## **Development Facilitation Team (DFT) – Review Comments**

**Project No: PR-2023-008085      Date: 04/10/2024      Agenda Item: #7 Zone Atlas Page: E-14**

**Legal Description: TRACT A-1, SPANISH WALK**

### **Application For: SD-2023-00187-PRELIMINARY PLAT ( DHO)**

NEW EASEMENTS

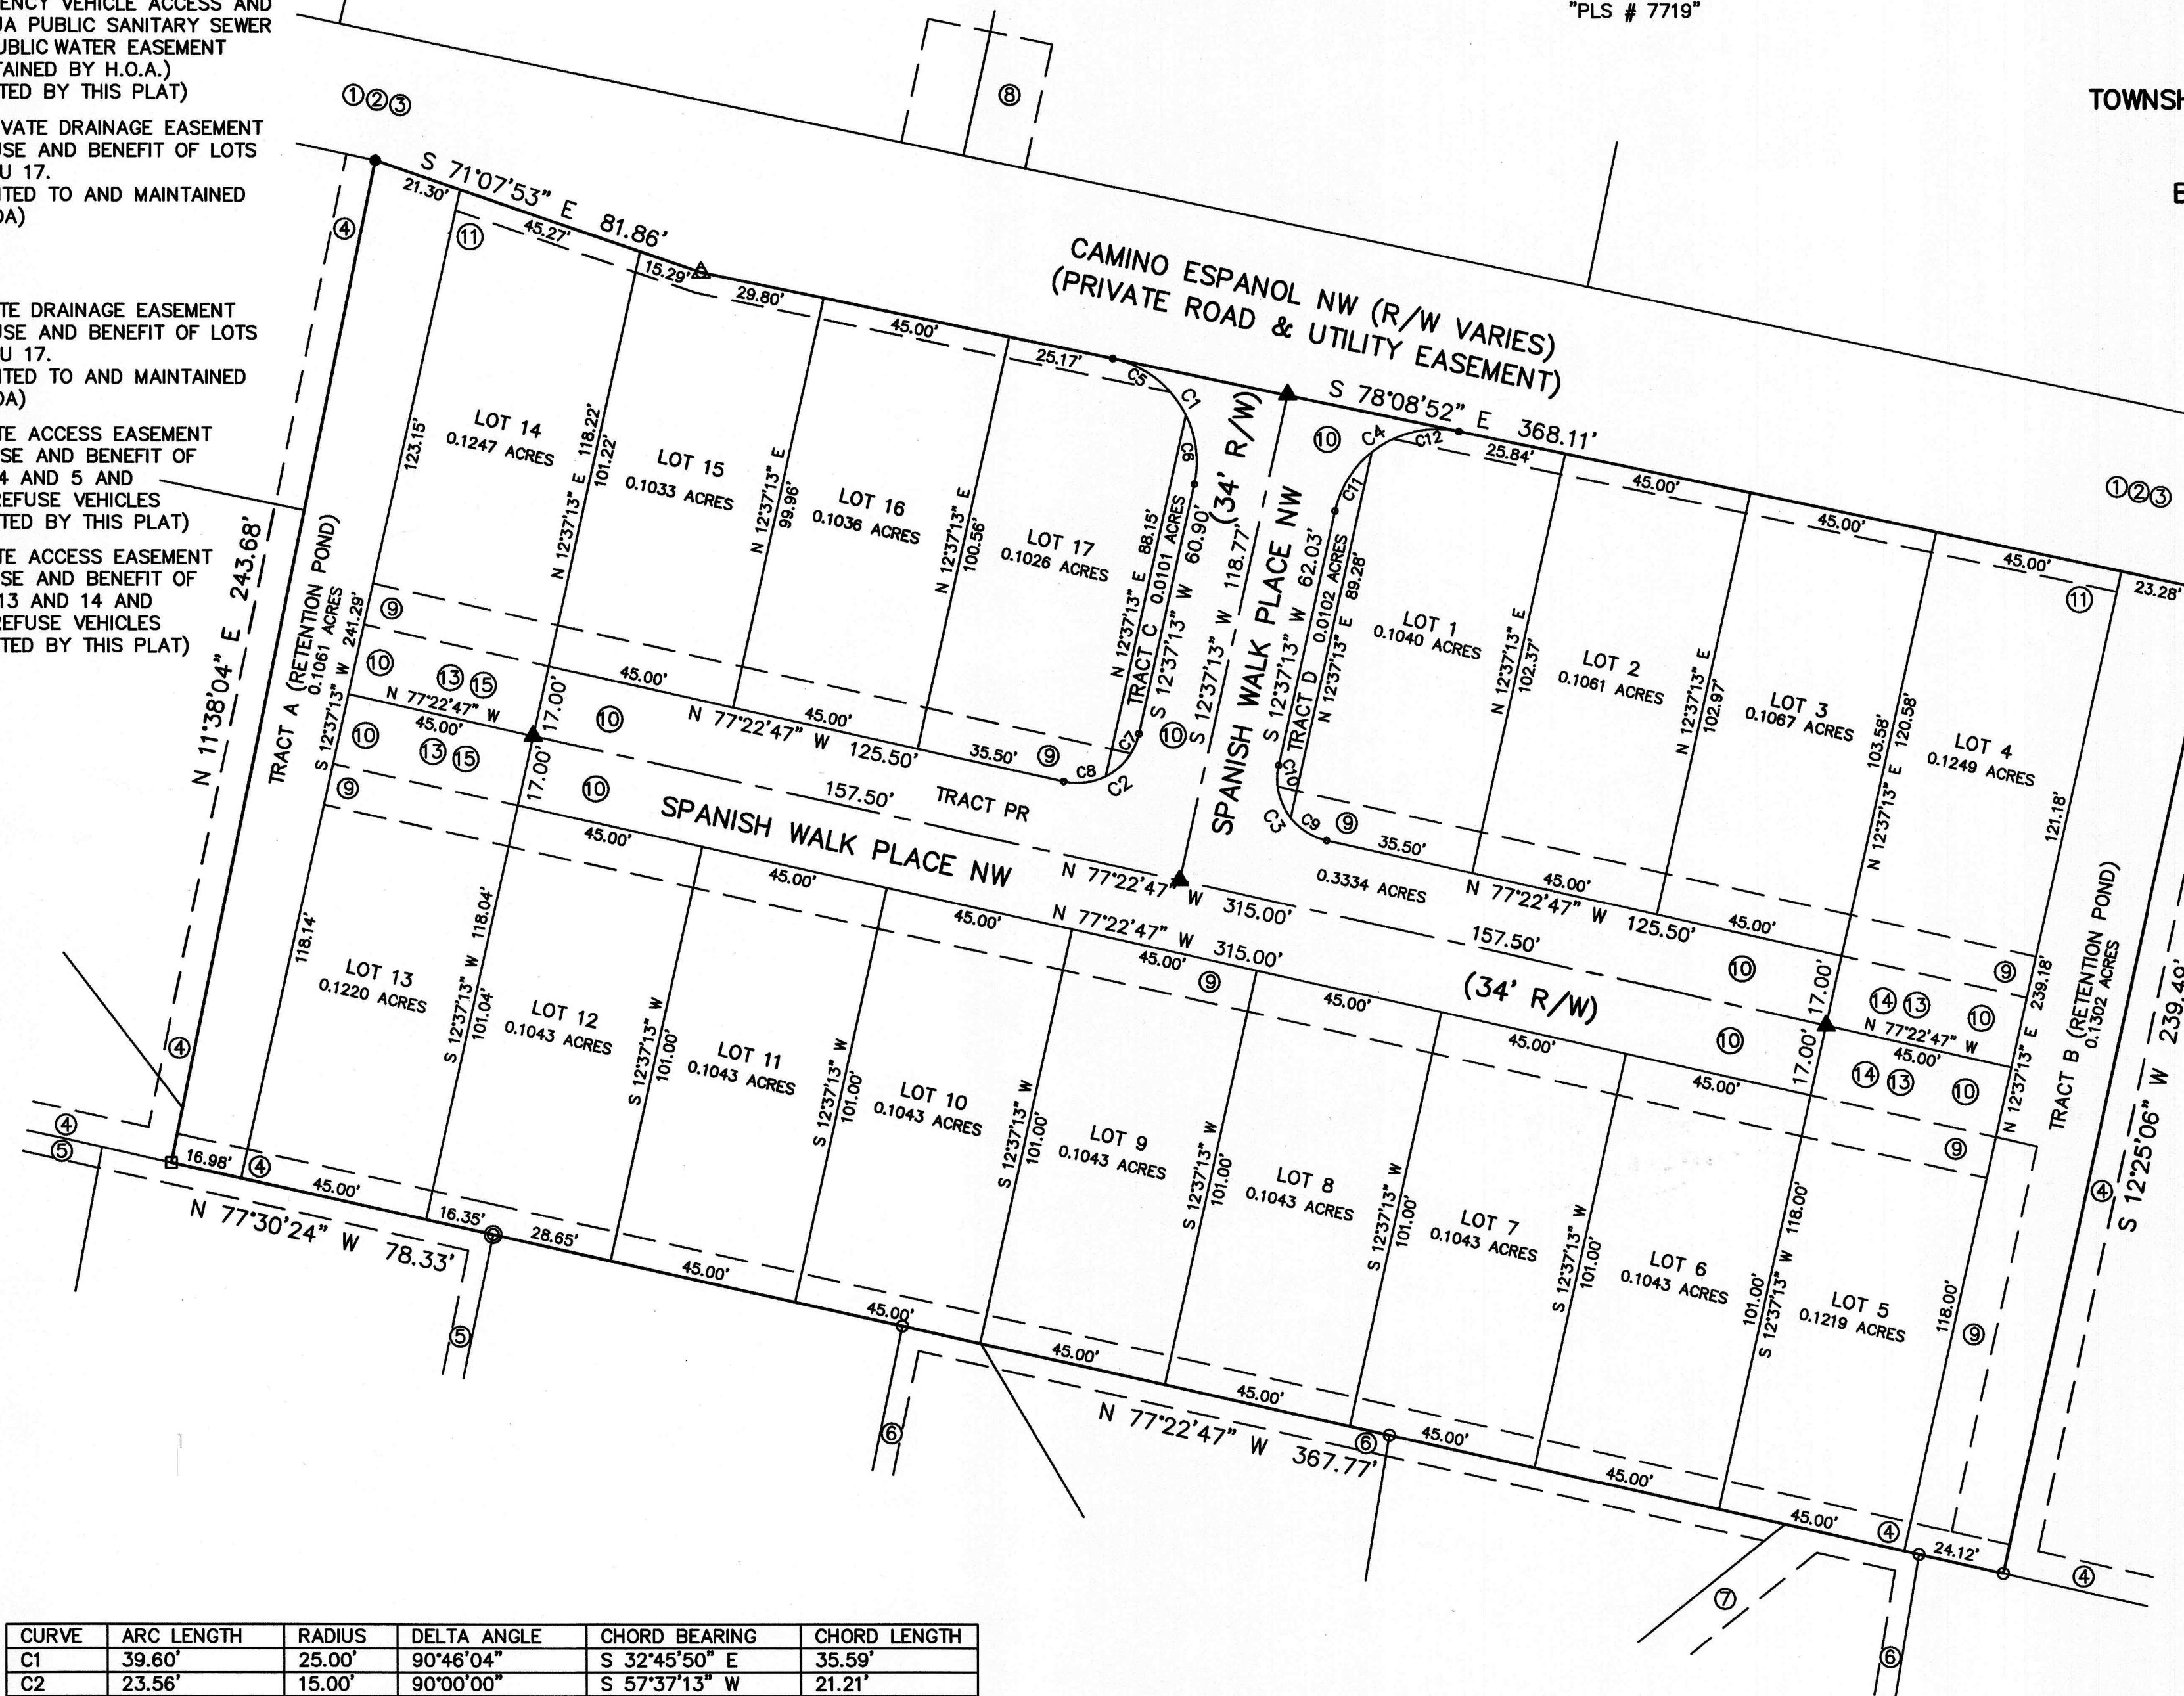
2. Please coordinate with Utility Development to make minor corrections to the infrastructure list.
3. Please change note 10 to include “Public” water and “Public” sanitary sewer easement.
